# \_Baseline

## Cherwell Planning 21/04179/LB and 21/04202/F

The application 21/04179/LB for a Listed Building Consent relates to the remedial works required to Trelawn House, in association with the larger application submitted for the redevelopment of the former Buzz Bingo site for 80 retirement living apartments. That application, 21/04202/F, refers to: Redevelopment for 80 retirement living apartments including communal facilities, access, car parking and landscaping.

Drawing Title
TRELAWN HOUSE - EXISTING ELEVATIONS
PLANNING APPLICATION

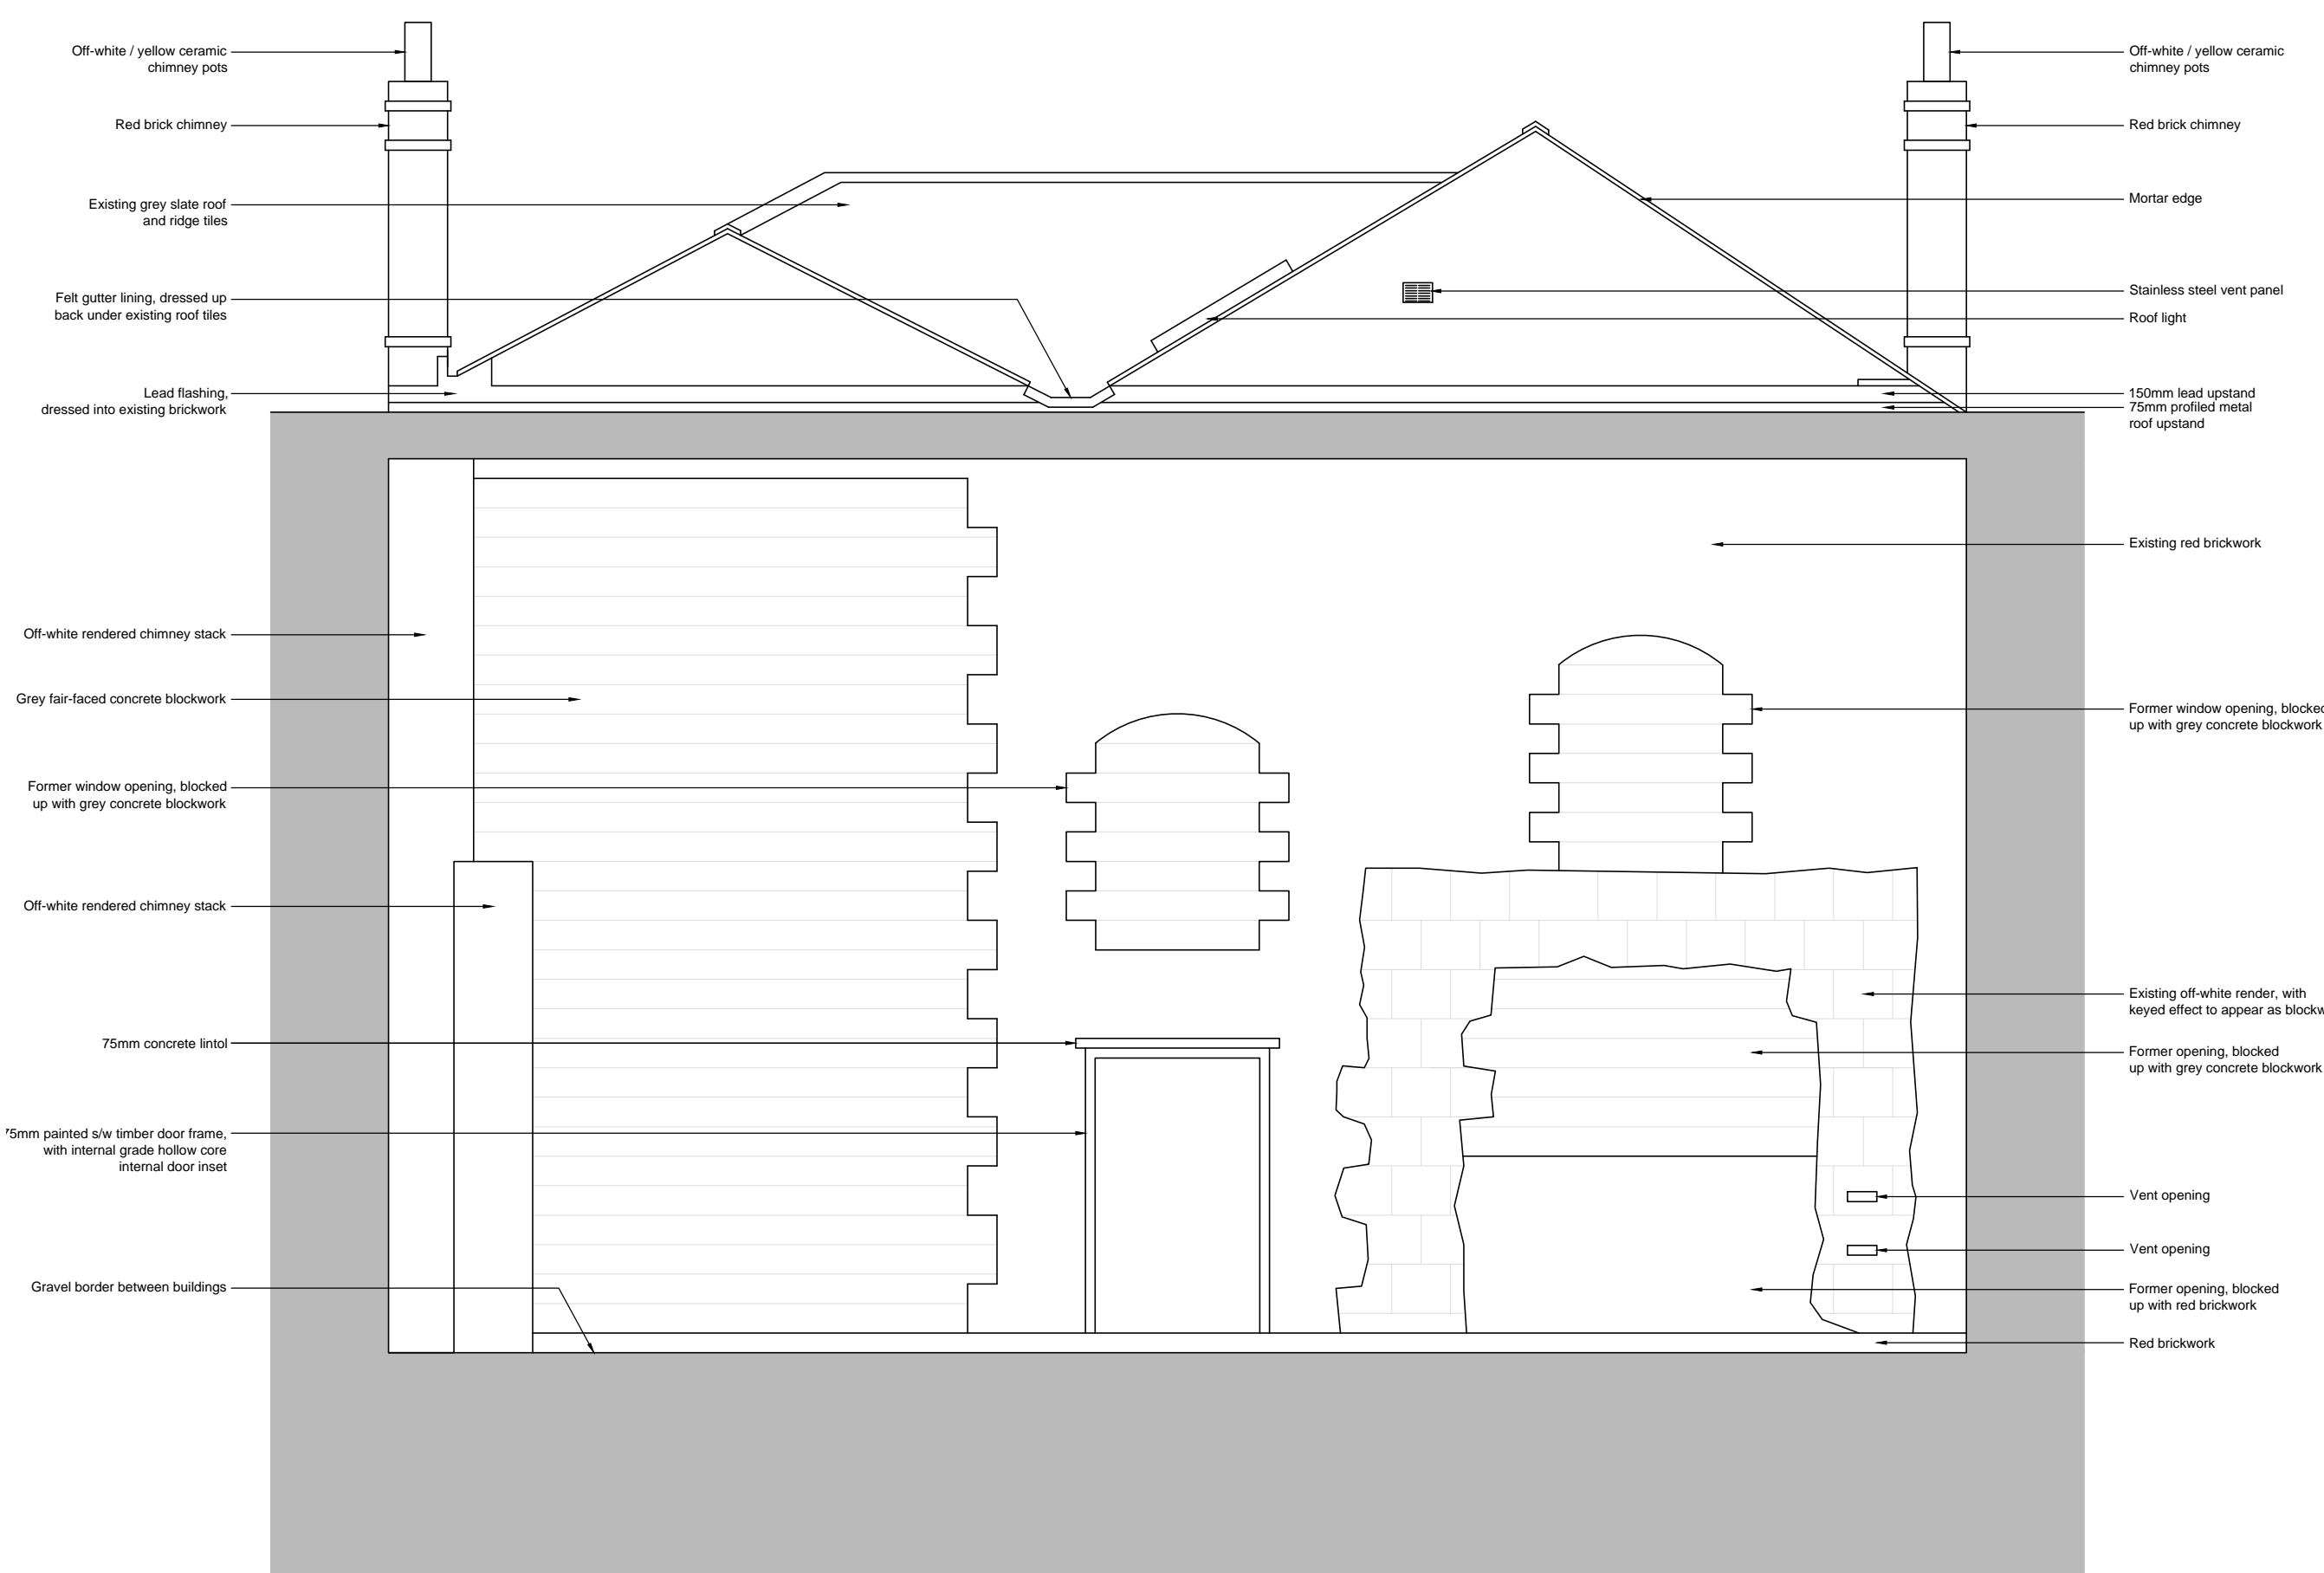
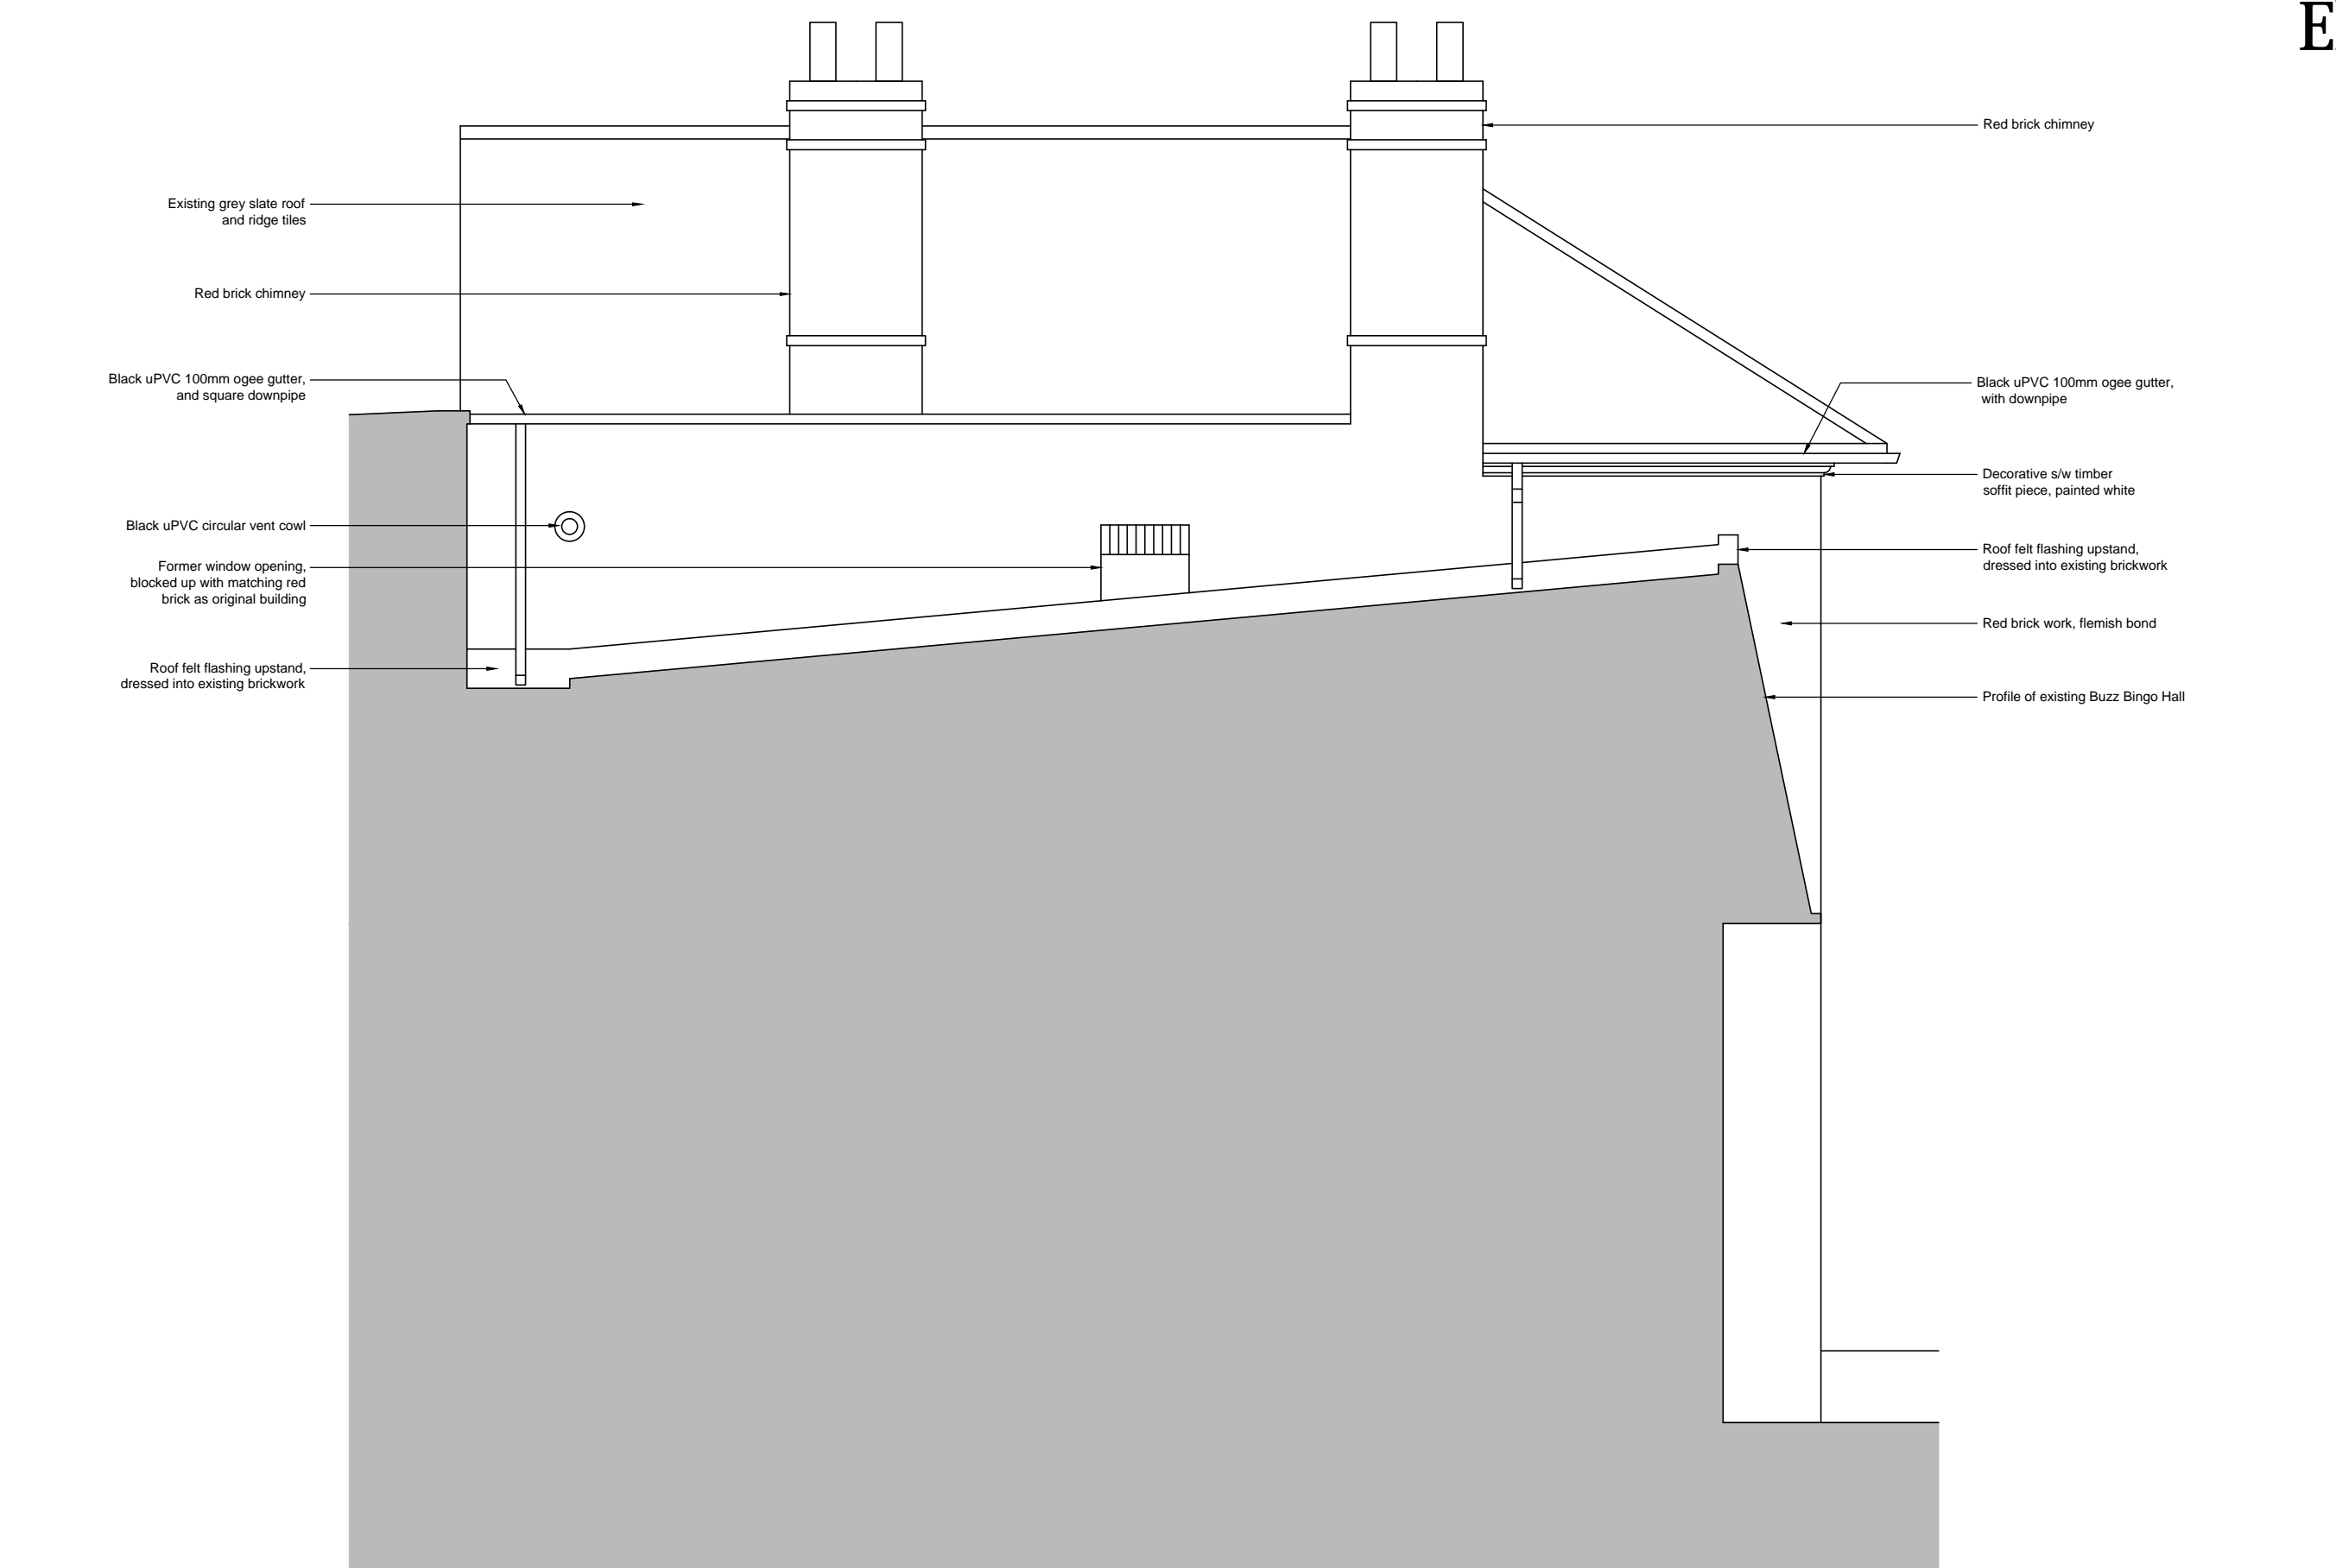
I do welcome reinstating views towards the northern elevation, yet express my strong concern regarding the proposed treatment on the northern face of the handmade listed brick. The proposed application of an external lime mortar render coat is totally contrary to the character of the property, and will destroy the integrity and historic character of the exposed elevation.

The elevation has historically faced the site corner and had openings, which could be now reinstated. The historic handmade brick should be repointed, restored and remain exposed as per original building settings.

I note that the applicant has also indicated that they intend to 'repair' and reinstate the exposed side elevation of Trelawn House with a render finish. This is a wholly inappropriate external treatment of the Listed Building (it was originally a fine freestanding brick built building), which should be identified to be restored with appropriate high quality brick.

Drawing Title
PROPOSED NORTH BAR STREET ELEVATION
PLANNING APPLICATION

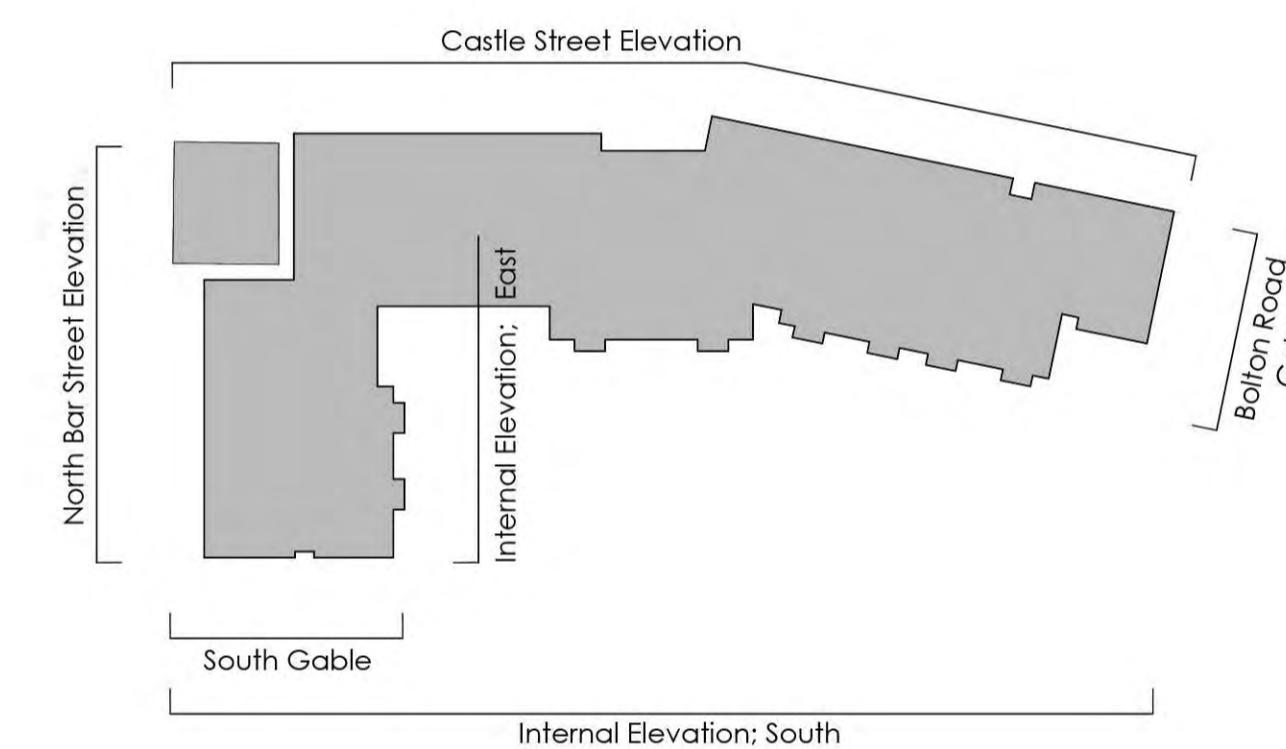
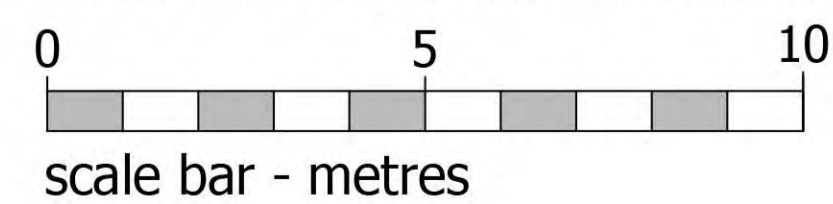
The proposed development is not sufficiently set back from the listed building to achieve an effective separation, leaving less than one meter gap to rear and southern façades of the building.

The design of the proposed south western part of the new development dwarfs the listed property, and by its scale will draw attention away from Trelawn, overshadowing and providing a pastiche of the former historic streetscape and building line.
